From: Simon Davis
Sent: 15 September 2020 12:51
To: Planning Scanning
Subject: FW: Hook Lane, Aldingbourne AL/57/20/DOC

Application Correspondence ref AL/57/20/DOC

Subject: RE: OWC application for Hook Lane site Aldingbourne

Drawing Title: DRAINAGE LAYOUT

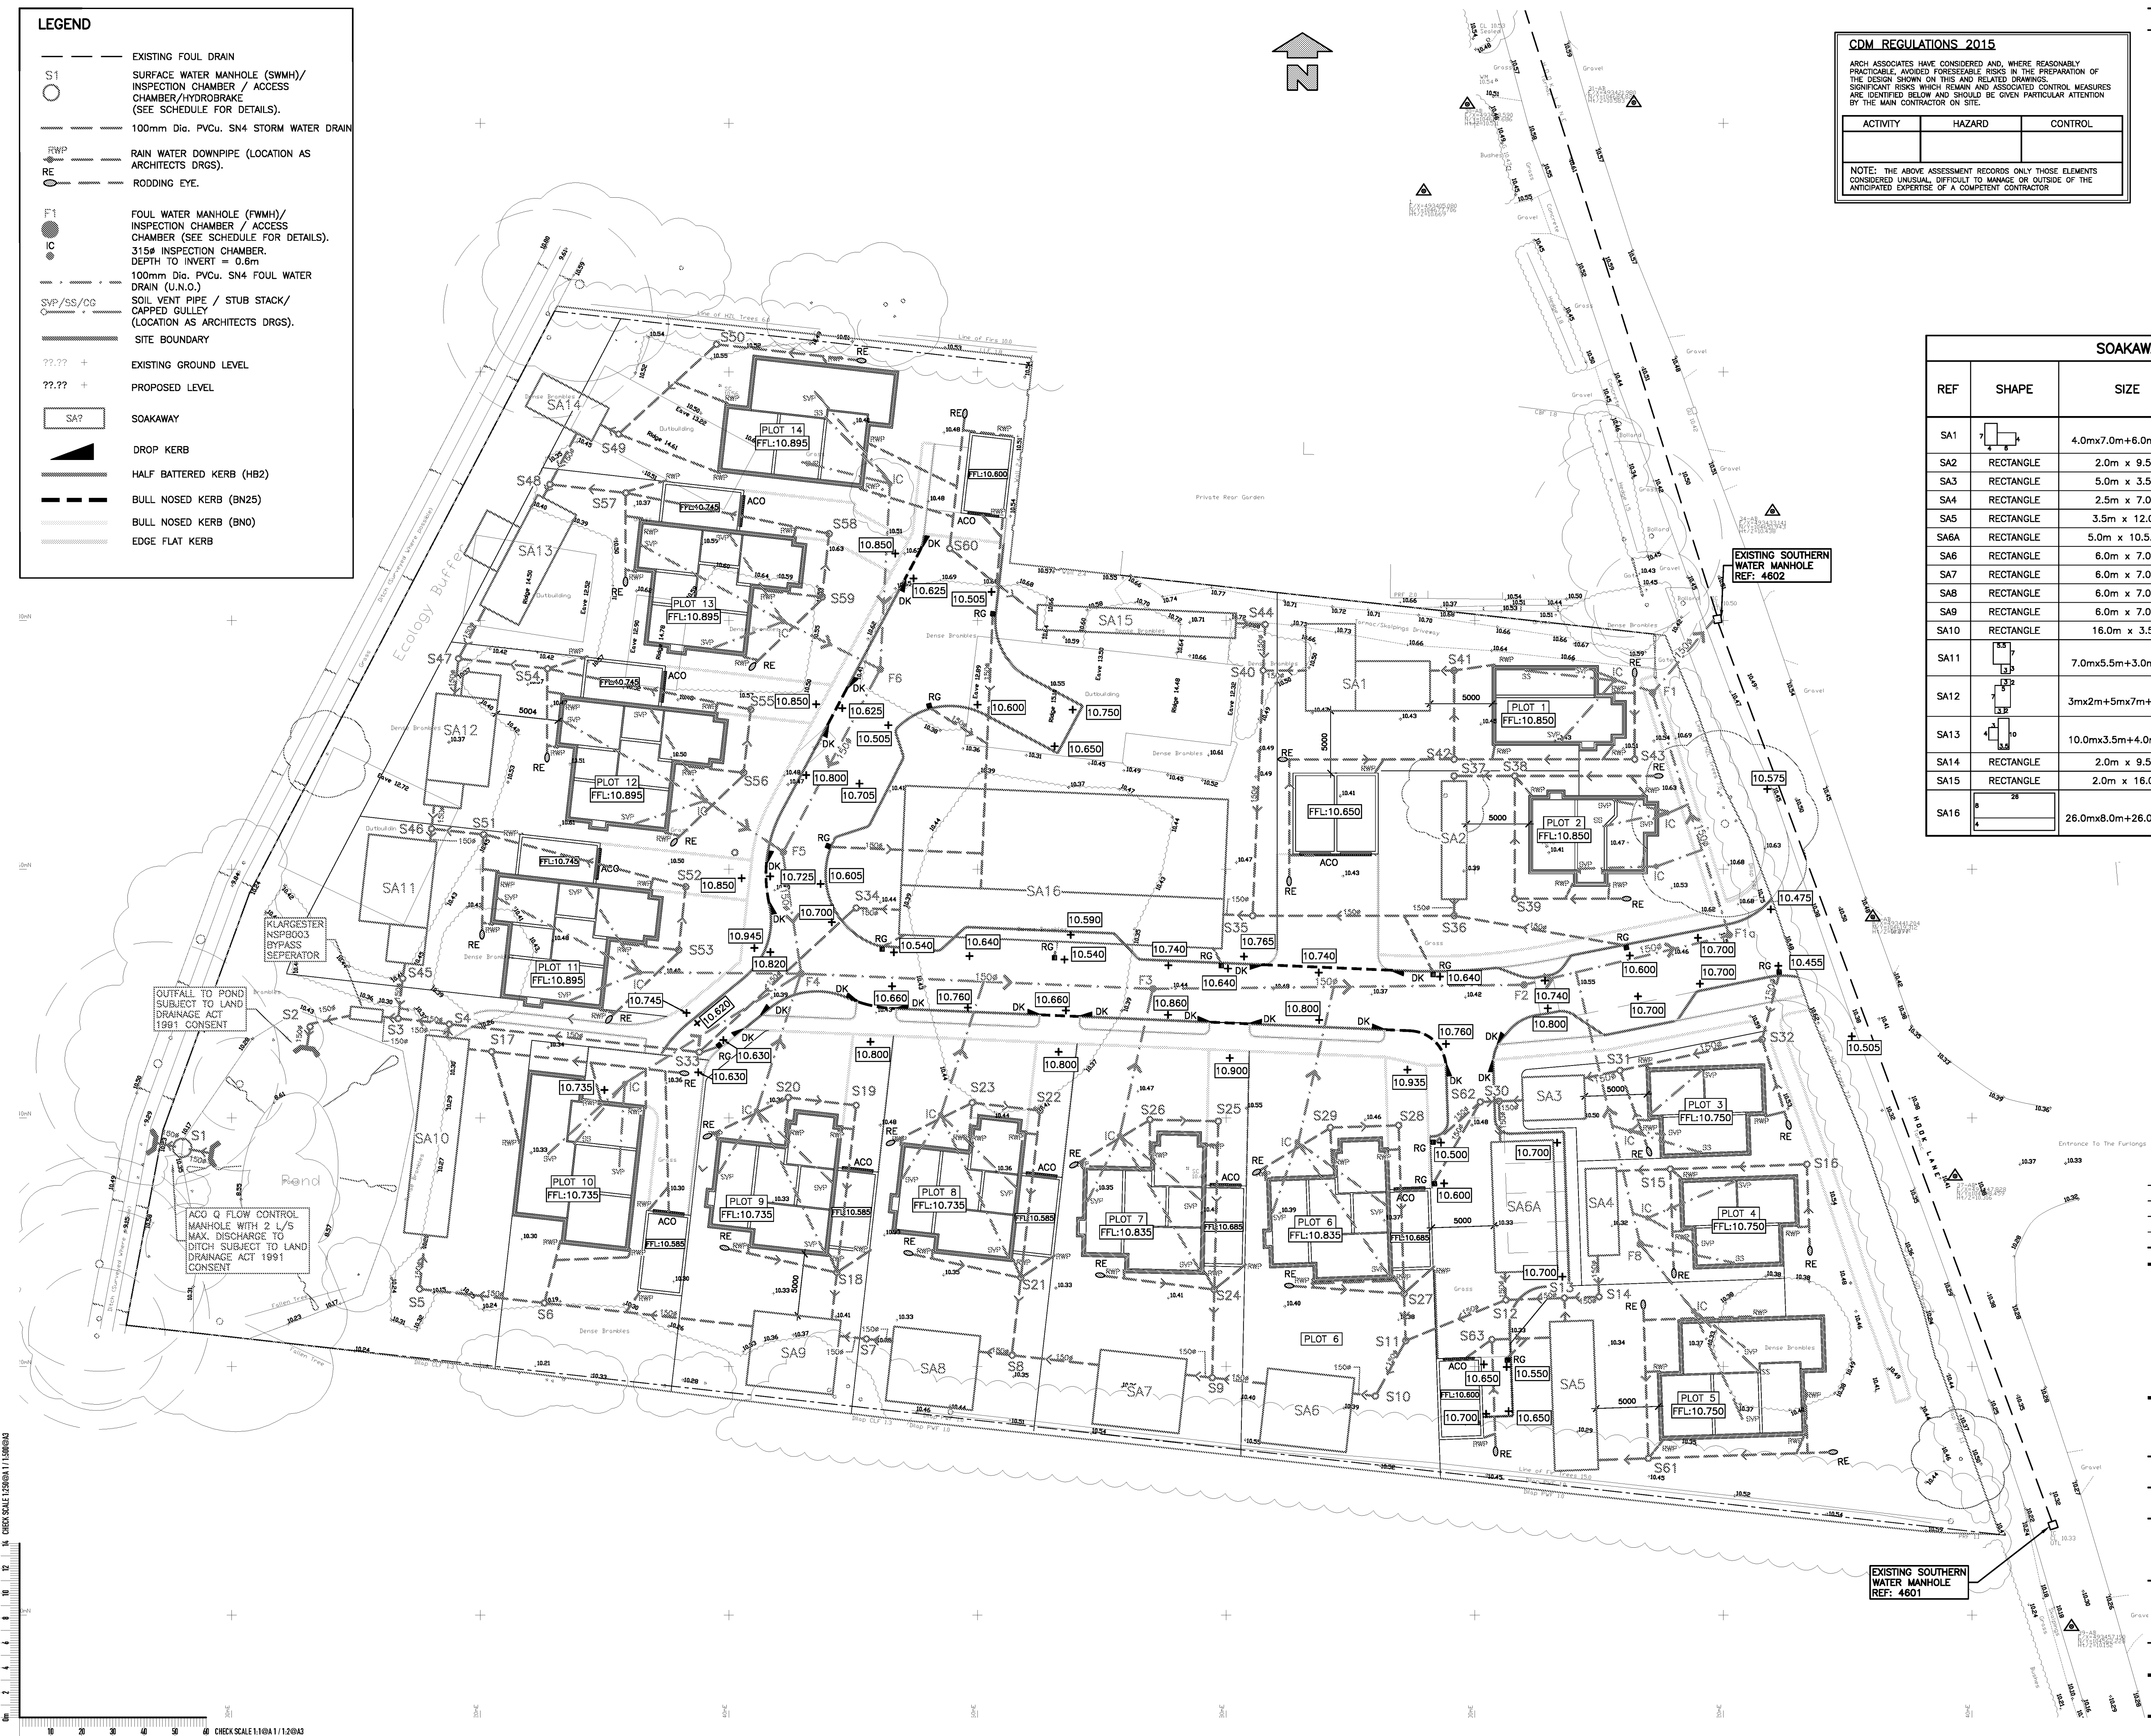
4. Hydrobrake chamber detail shows 100mm diameter outlet pipe. Plan shows 150mm. Please correct as necessary.
5. Is there a gradient on the pipe between then hydrobrake chamber and the upstream headwall? See levels on plan for S1 inlet/outlet ie. 9.73 and pond outlet at 9.73.

ELEVATION OF HEADWALL OUTLET INTO & OUT OF POND (WITH SUMP)
(1:25)

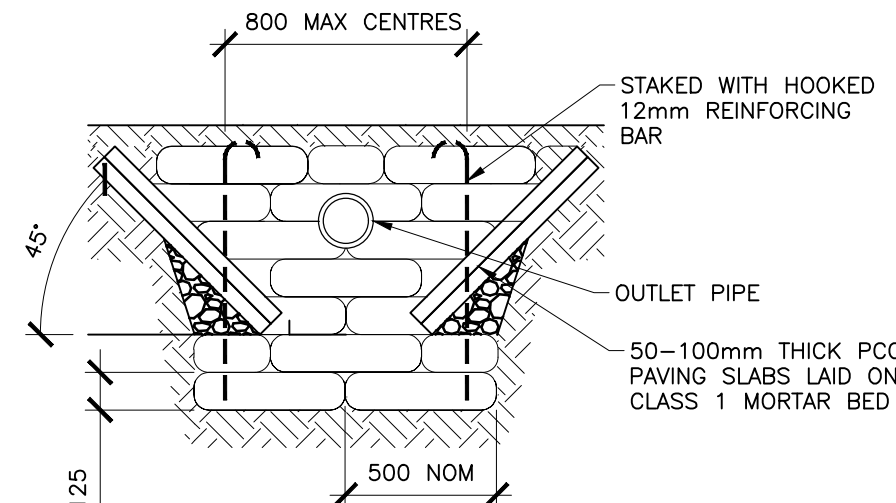
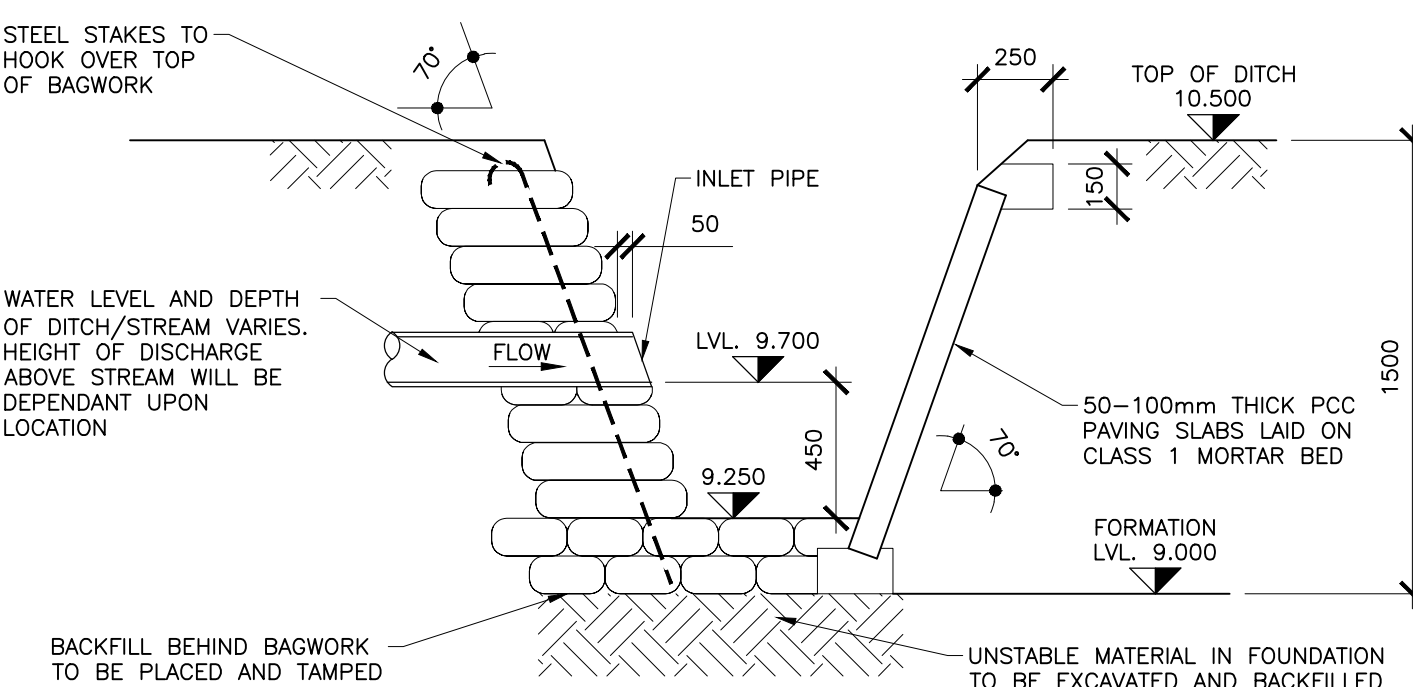
8. Inlet to pond;
 - a) Specify plan area dimensions of sump.
 - b) Add note; no part of headwall structure to encroach into profile of the pond.
 - c) Construction detail should show/acknowledge the fact that it is being formed in the side of a pond, not a ditch ie. adjust detail/note downslope of sump.

- d) Having not seen the pond bank at this location, does it warrant further erosion control measures beyond the sump?
9. Outlet from pond;
 - a) A cranked trash screen to suit a 150mm diameter pipe is required to help protect the hydrobrake from blockage.

- b) Modify the headwall design to suit/accommodate item a).

ELEVATION OF HEADWALL OUTFALL FROM POND TO SIDE OF DITCH
(1:25)

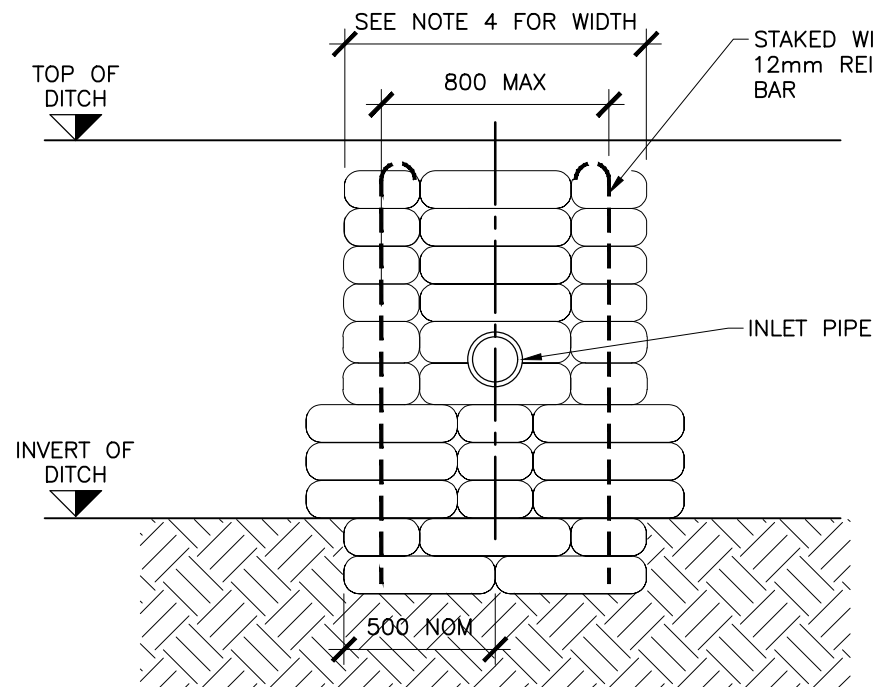
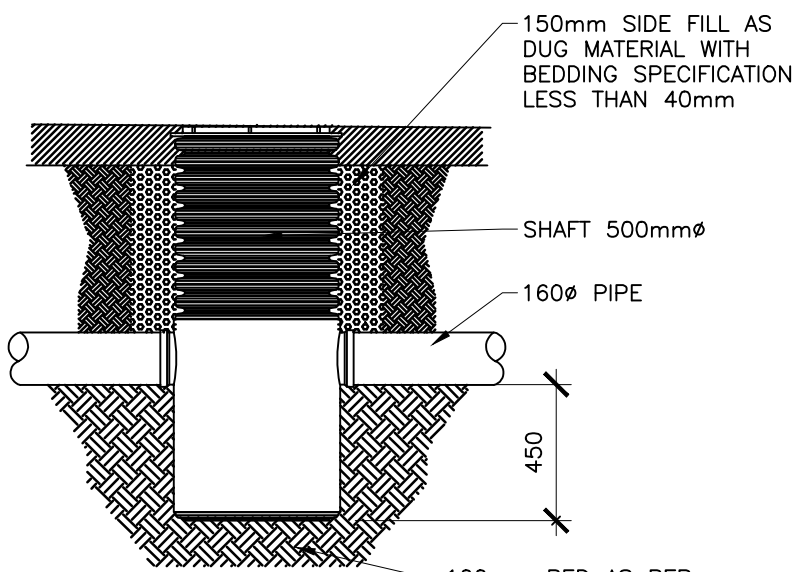
6. Has the pond been cleaned out/need cleaning out? Add note on drawings as necessary.
7. Outlet to ditch;
 - a) Add note; no part of headwall structure to encroach into profile of the ditch.

- b) The apron level of 9.250 must be the true bed level of the ditch ie. not silt level. Please confirm/stipulate.
 - c) Indicate extent/length of paving slab bank protection.
